RE: SUB19-002/SEP19-005 – Proposed Preliminary Plat  
2825 W. Mercer Way, APN 2174502425  
Request for Additional Information, Third Review  
Blueline Job No. 13-118

This letter is in response to your review of the SUB19-002/SEP19-005 project. The plans have been revised per the comments in your letter dated 1/09/23. Below is a list of each comment with our responses in bold.

2/16/23
 JOB NUMBER: **13-118**
 SHEET NAME: **GP-01**
 SHT **4** OF **9**

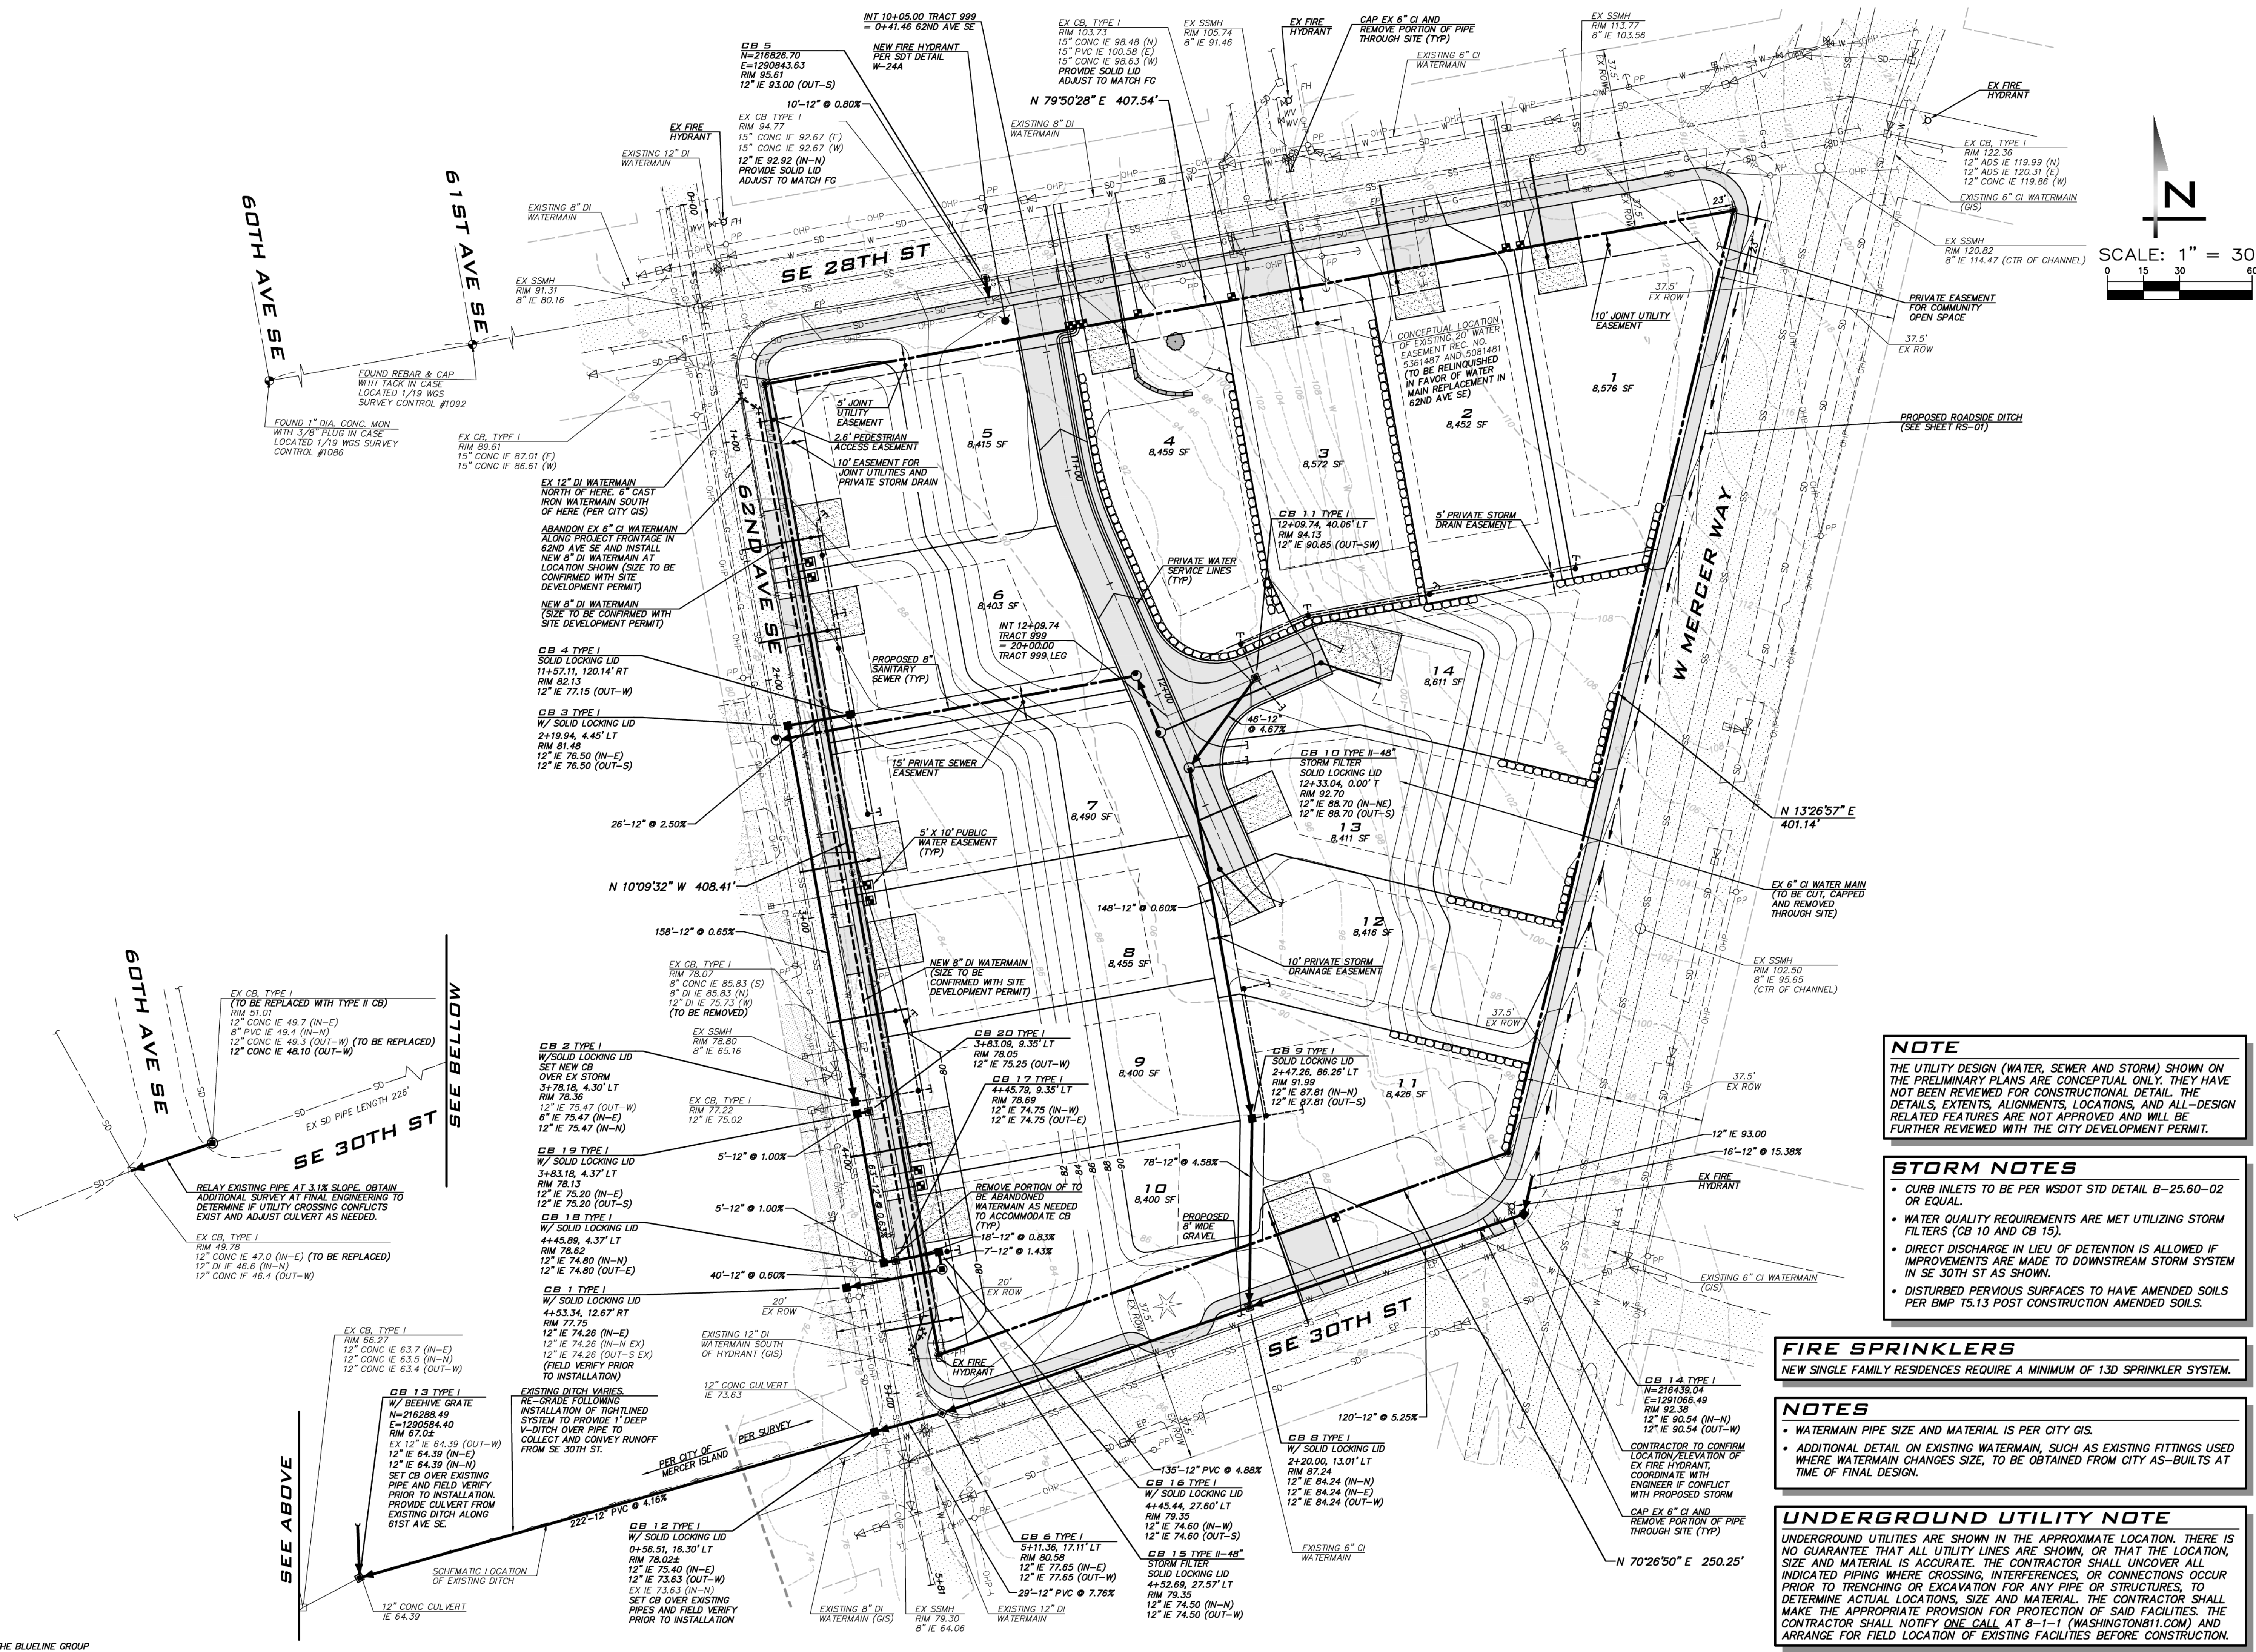
1. Second repeat correction. A new wall not shown in Sub 1 looks to be within the tree protection zone. The construction of the wall as shown would encroach into the tree 2's protection zone. Place this wall with enough room to construct without encroaching into the tree protection zone. As suggested in a Planning comment a longer driveway would resolve this issue. The building pad, driveway, grading and wall to be shown outside that limit with enough space to reasonably construct building. This means showing at least 5' of space between building pad and driveway in addition to the 16' of protection. SUB3 still shows the retaining wall right against/within the tree protection. This could not be built without taking the tree protection down and encroaching into tree 2's limits of allowable disturbance. A call out states 5 feet between the tree protection and wall and building pad. But this is not clearly shown. Show building pad and wall with this clearance. Move both the building pad and the wall to keep the 16-foot tree protection zone from the face of the tree to the chain link fence.

**The wall has been relocated so that it is a minimum of 1' off of the dripline/tree protection fence such that the tree protection fence can remain in place while the wall is installed. Given the height of the wall adjacent to the driveway (0'-2.5') and distance from the dripline/tree protection fence (1'-5'), the work to install the wall should fall outside of the dripline. Refer to details on sheet GP-01 showing grading in the area of tree #2. An additional callout regarding work adjacent to the dripline has been added to sheet GP-01 and TR-01. This approach was confirmed with the City on 2/16/23.**

2/16/23
 JOB NUMBER:
13-118
 SHEET NAME:
UP-01
 SHT **5** OF **9**

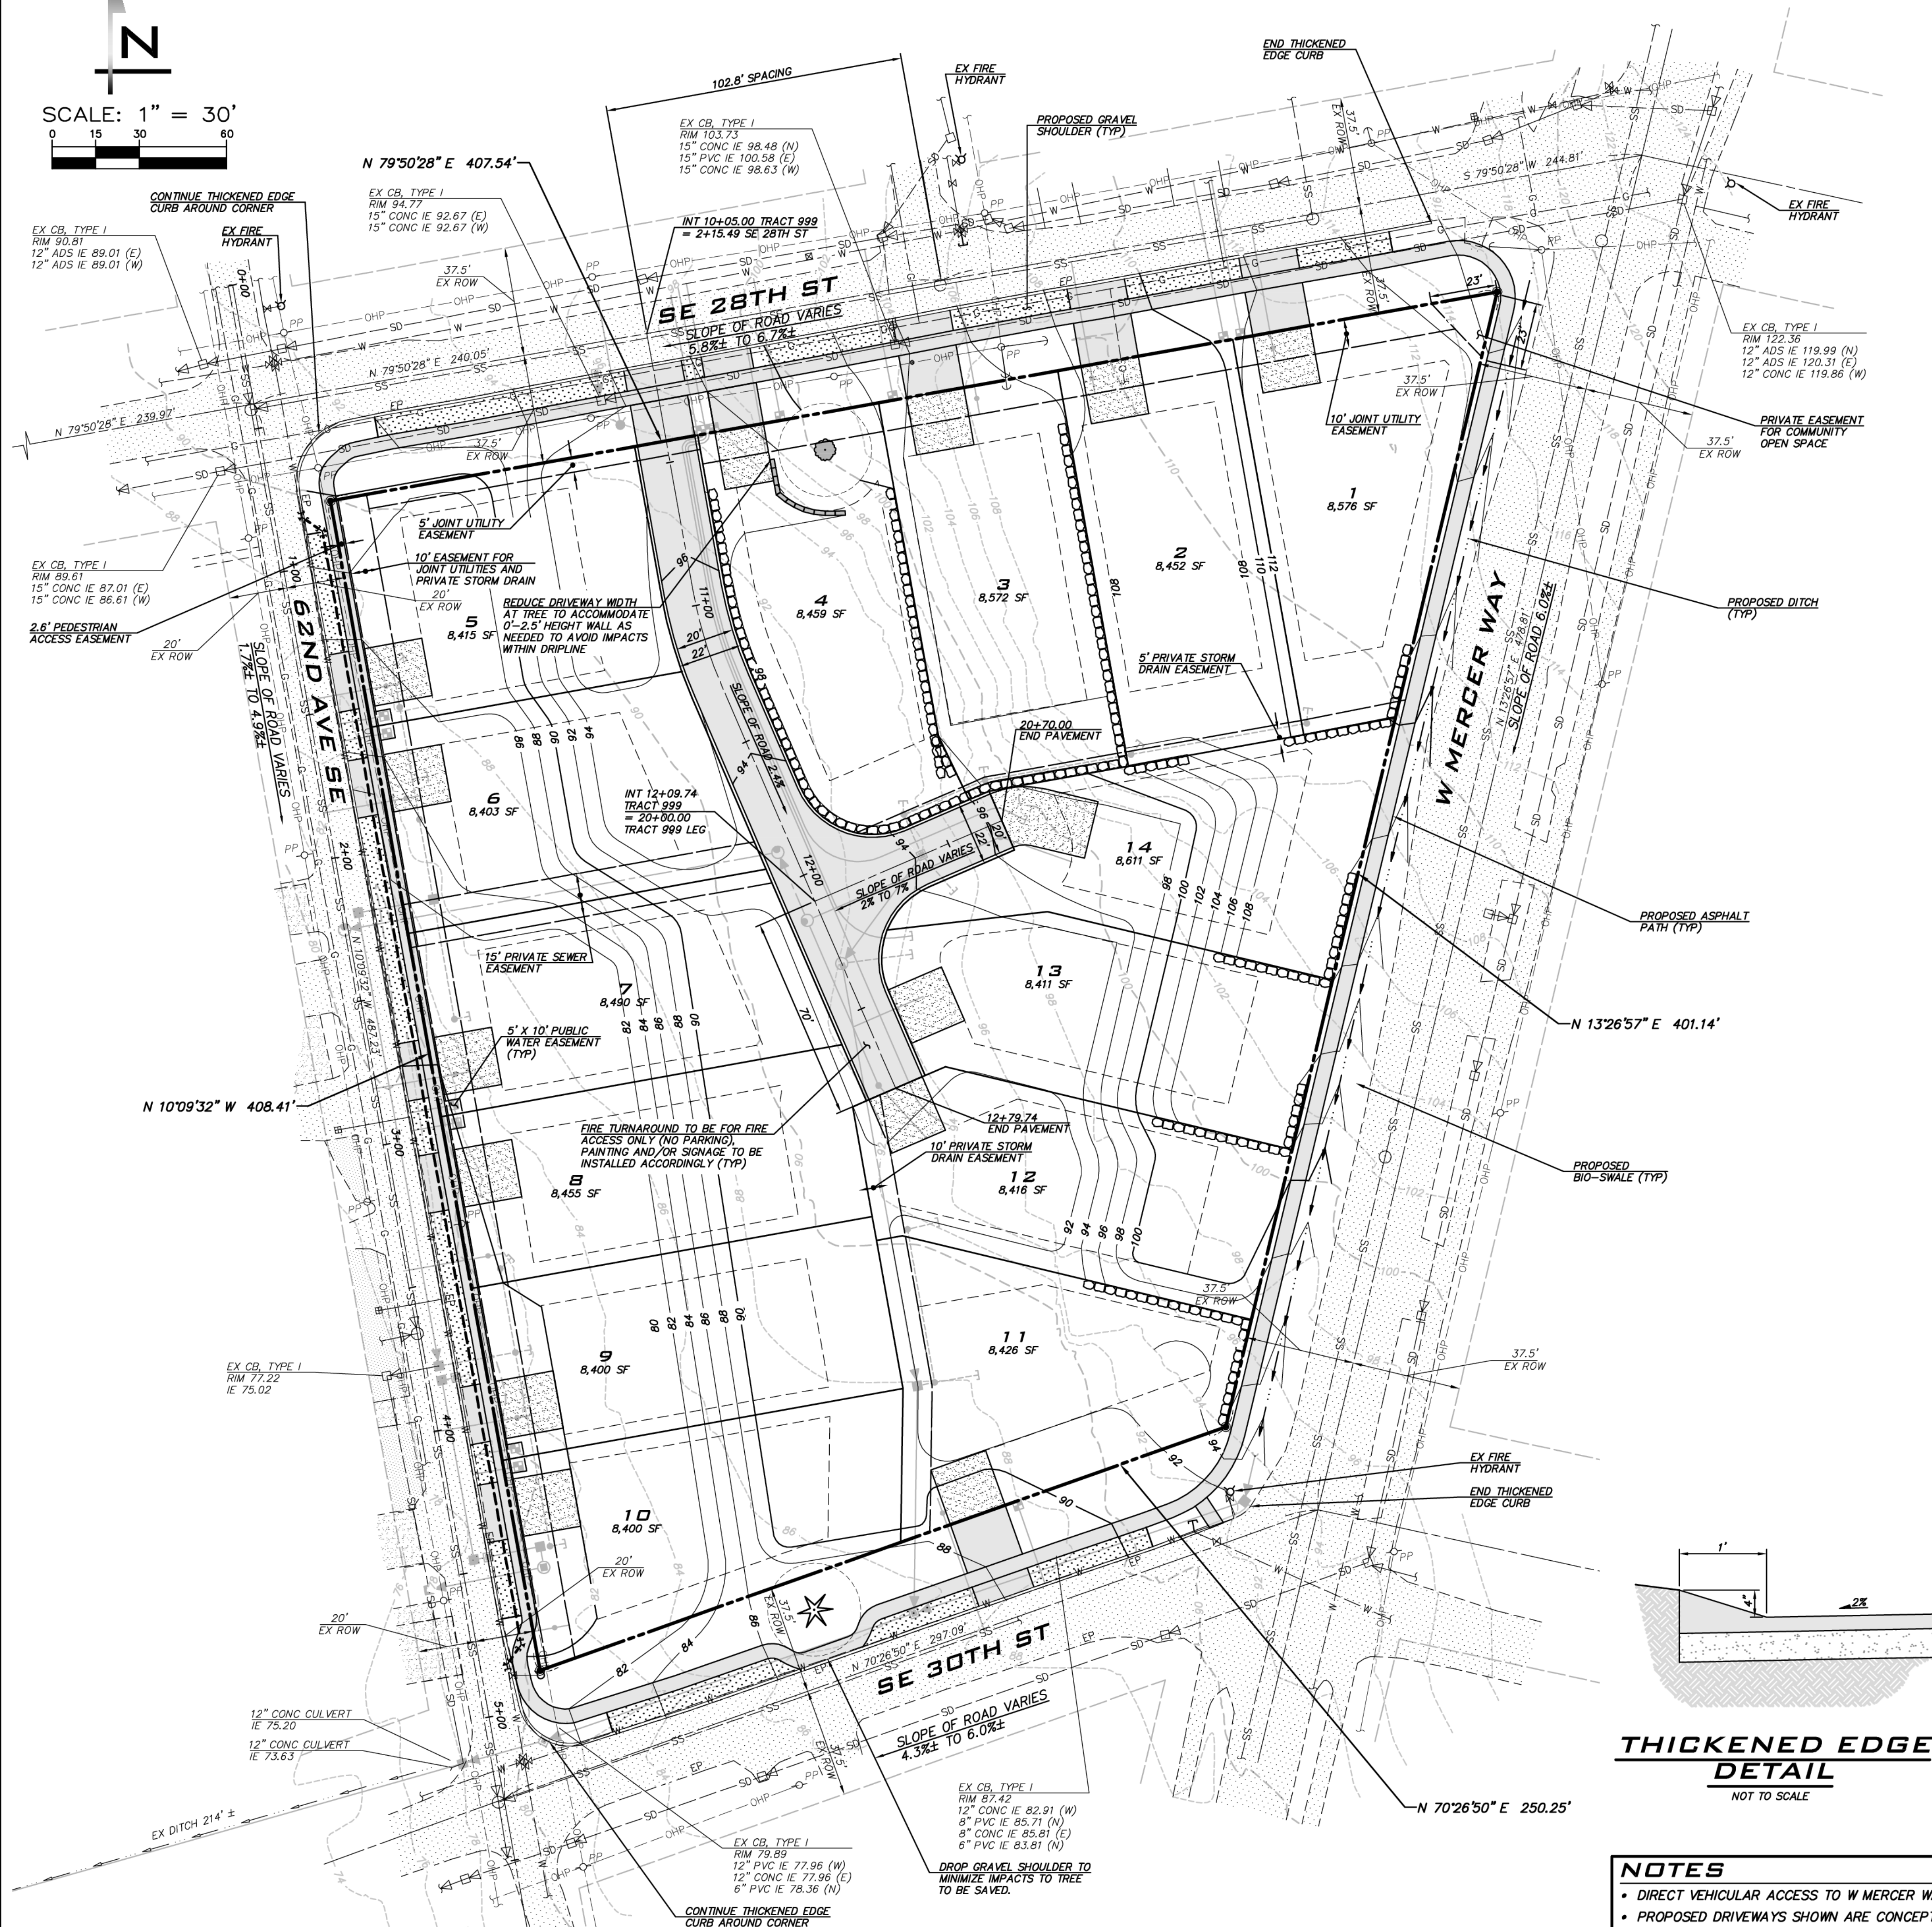
- f. The new water main will likely be a 12" DI and a water modeling will be required.

**Callouts for the proposed water main on sheet UP-01 have been revised to include notes for size to be confirmed with the Site Development Permit.**

5. Hydrant spacing- Does not meet standards: IFC C102 Number of Hydrants and spacing required. Hydrants shall be located within 250 feet from the hydrant to the fire department access. Additionally, fire hydrants shall be located within 300 feet from the furthest point of the residence (w/o fire sprinkler system) and 600 feet (with sprinkler system). Currently Lots 12-13-14 exceed the distance from a Fire Hydrant. Provide a solution/ code alternative to how this requirement will be met.

**A fire hydrant has been added at the SE 28th St/private access road intersection to meet the hydrant spacing standard. This spacing was confirmed with the City on 1/11/23.**
